Application for non-material amendment following a grant of planning permission.

REQUEST FOR INCREASE OF WIDTH OF PROPOSED EXTENSION

2043 23 100, 110, 200, 210

2043 23 100A, 110A, 200A, 210A

DRAWING TITLE: GROUND FLOOR PLAN
 AS EXISTING

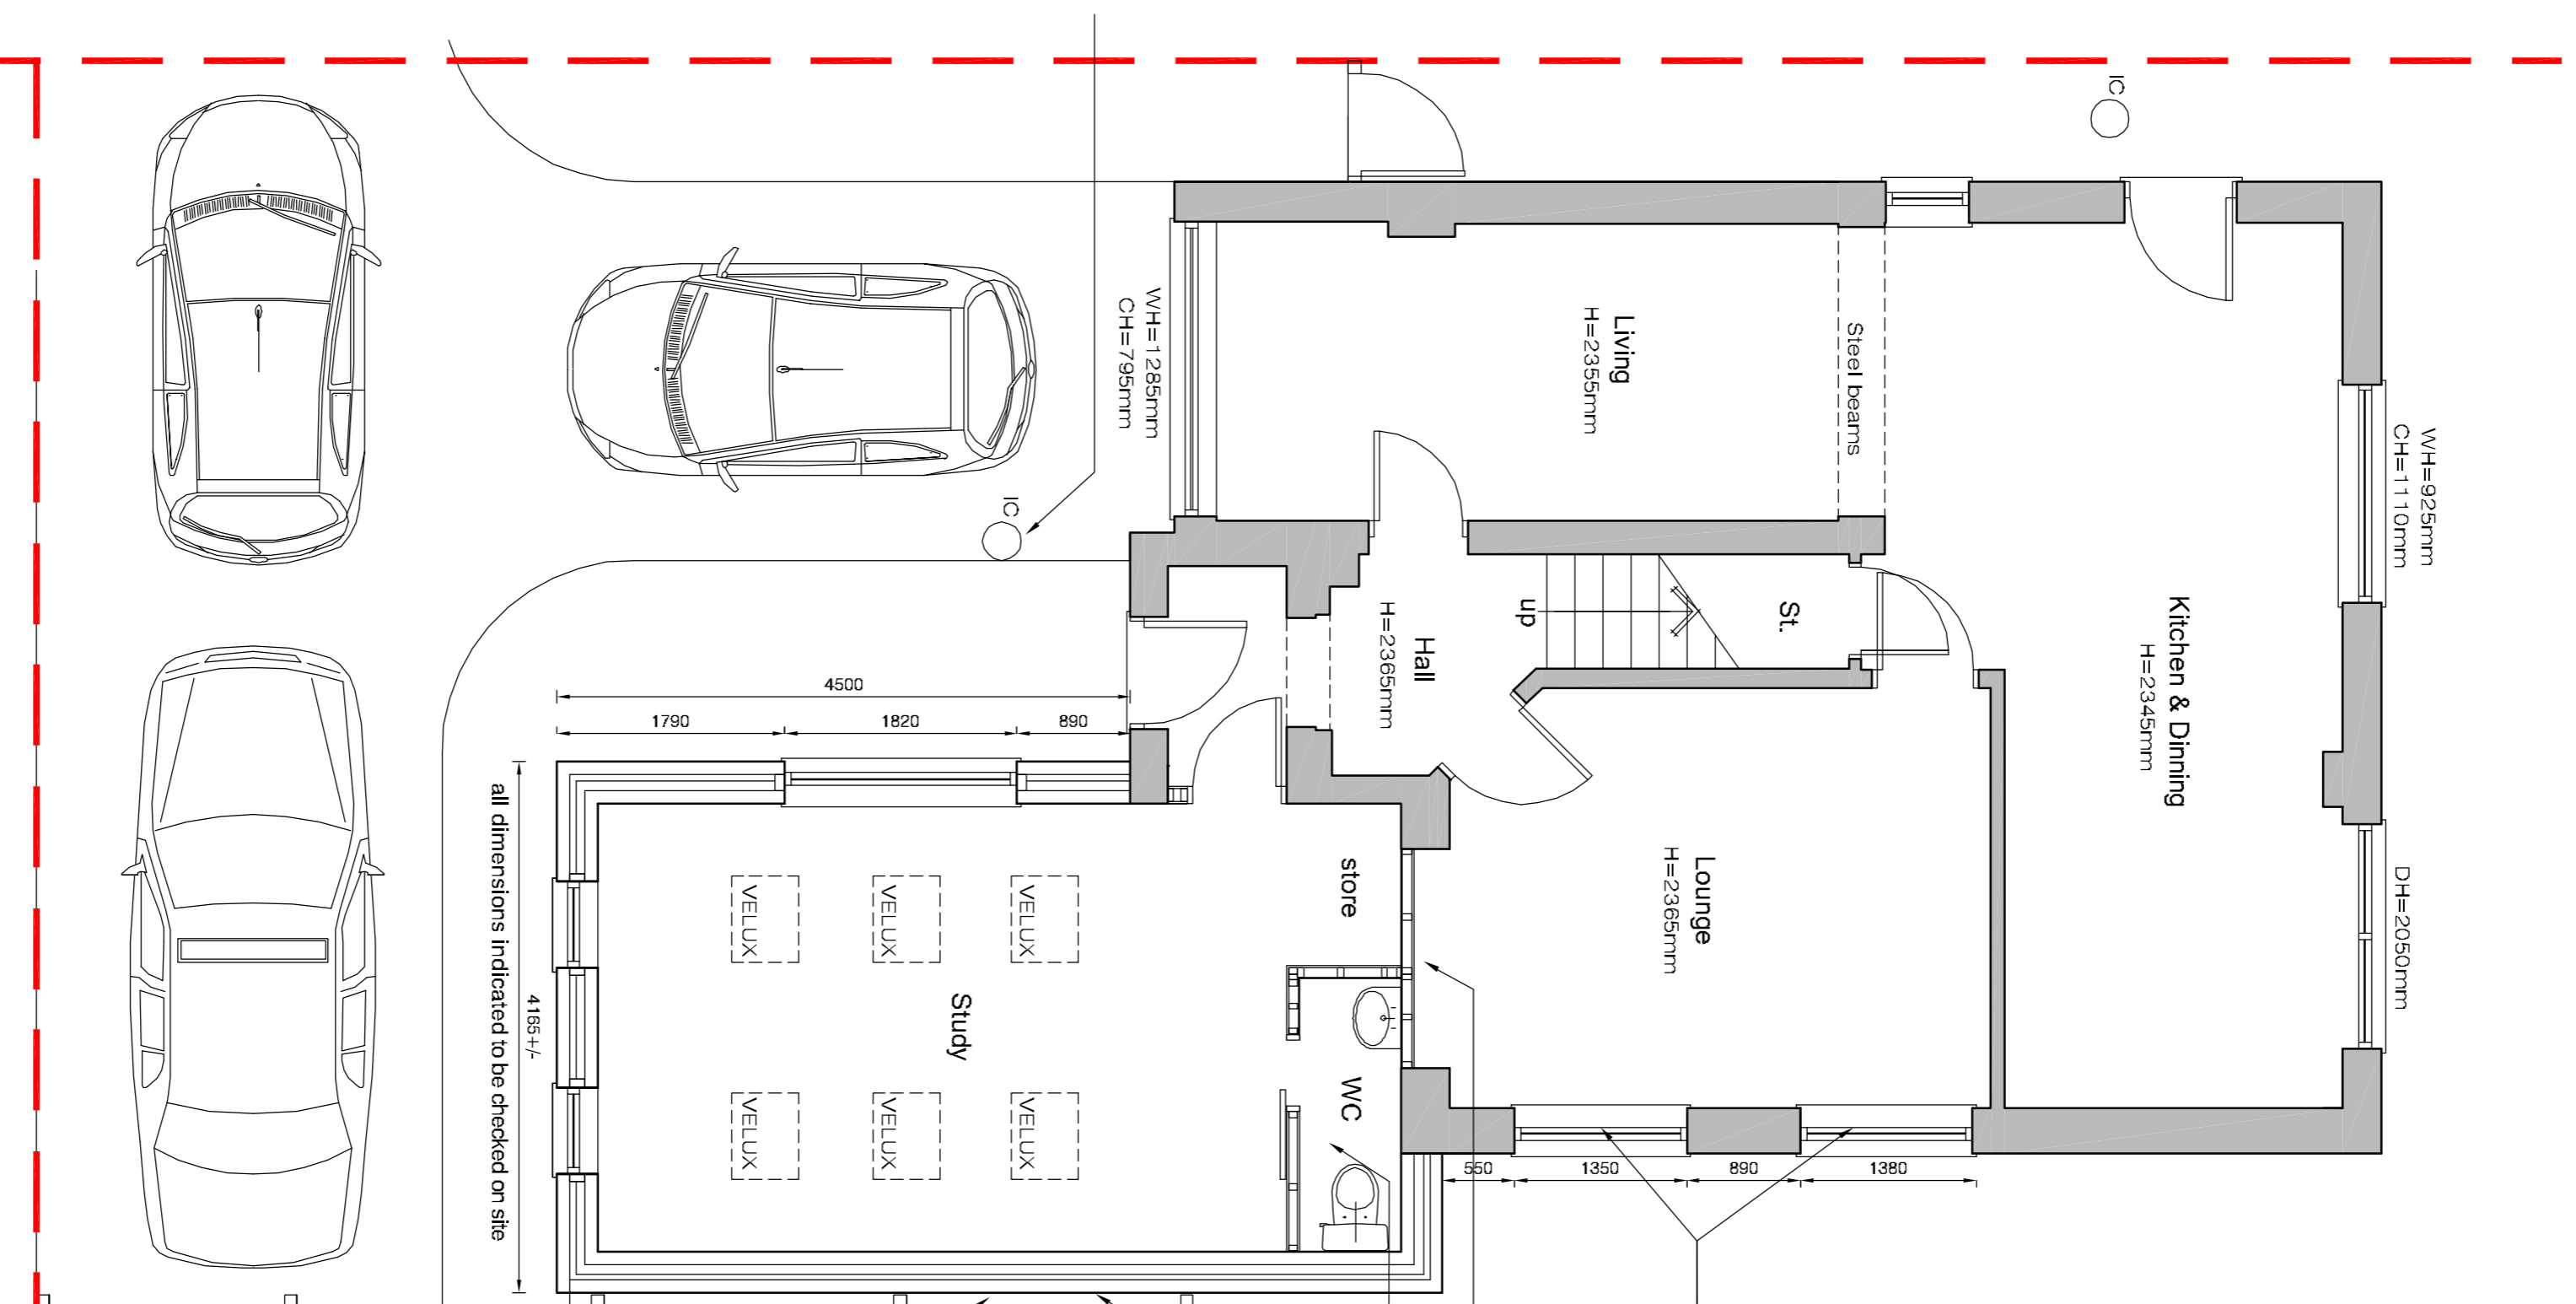
THE CLIENT HAS REQUESTED TO INCREASE THE EXTENSION WIDTH TO THE BOUNDARY.
